TS/MR
10051
7 December 2016

**RESPONSE TO SUBMISSION
SSD 16_7478 - STAGE 1A (SECOND STAGE) STRATUM SUBDIVISION - BARANGAROO
SOUTH**

PLAN OF PROPOSED SUBDIVISION  
LEVEL 1 SOUTH  
DATED: 16-11-2015

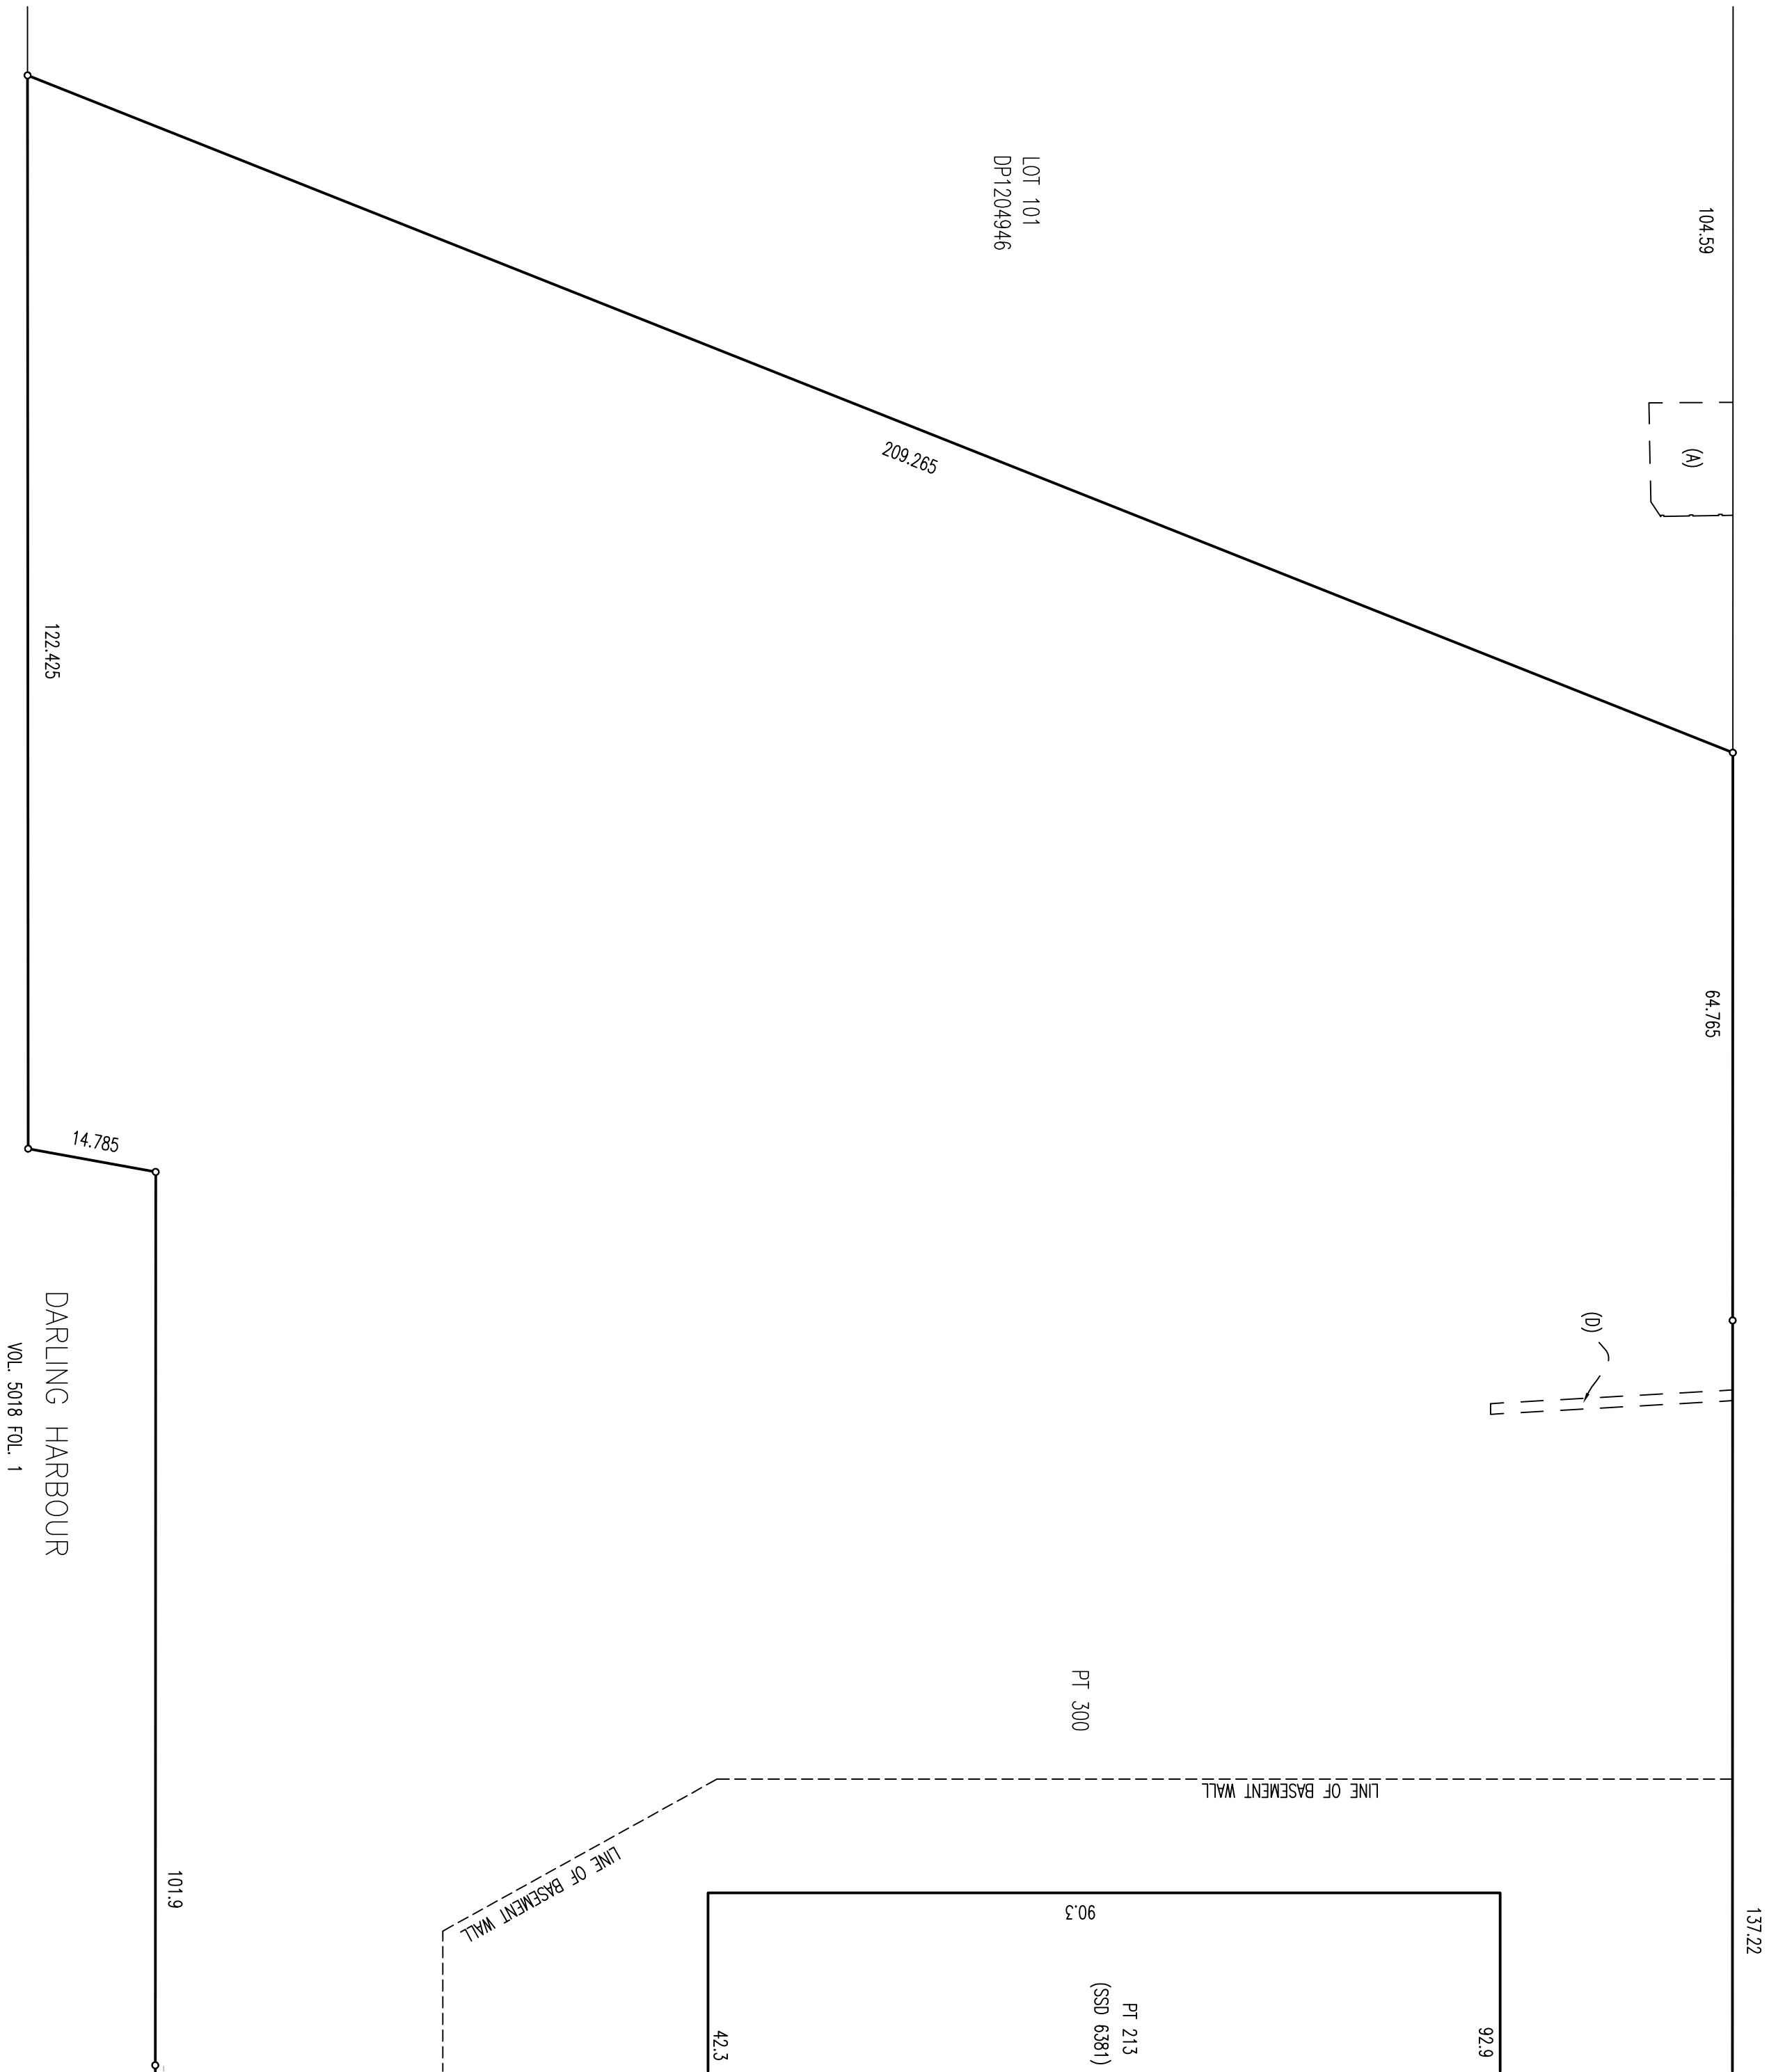
Additional plans have also been provided to the Department at **Attachment A**, which propose minor changes to the subdivision layout in order to ensure consistency with the future Metro alignment. Specifically, the Building C2 End of Trip Facilities and the future Metro lift area have been adjusted to ensure consistency with the Metro Deed agreed with by the Barangaroo Delivery Authority (BDA) and Transport for NSW (TfNSW) in respect to the East-West Metro alignment. It is requested that the existing submitted plans be substituted for those attached as applicable, specifically regarding:

- Plan of Proposed Subdivision Level 1 South; and
- Plan of Proposed Subdivision Level 2 South.
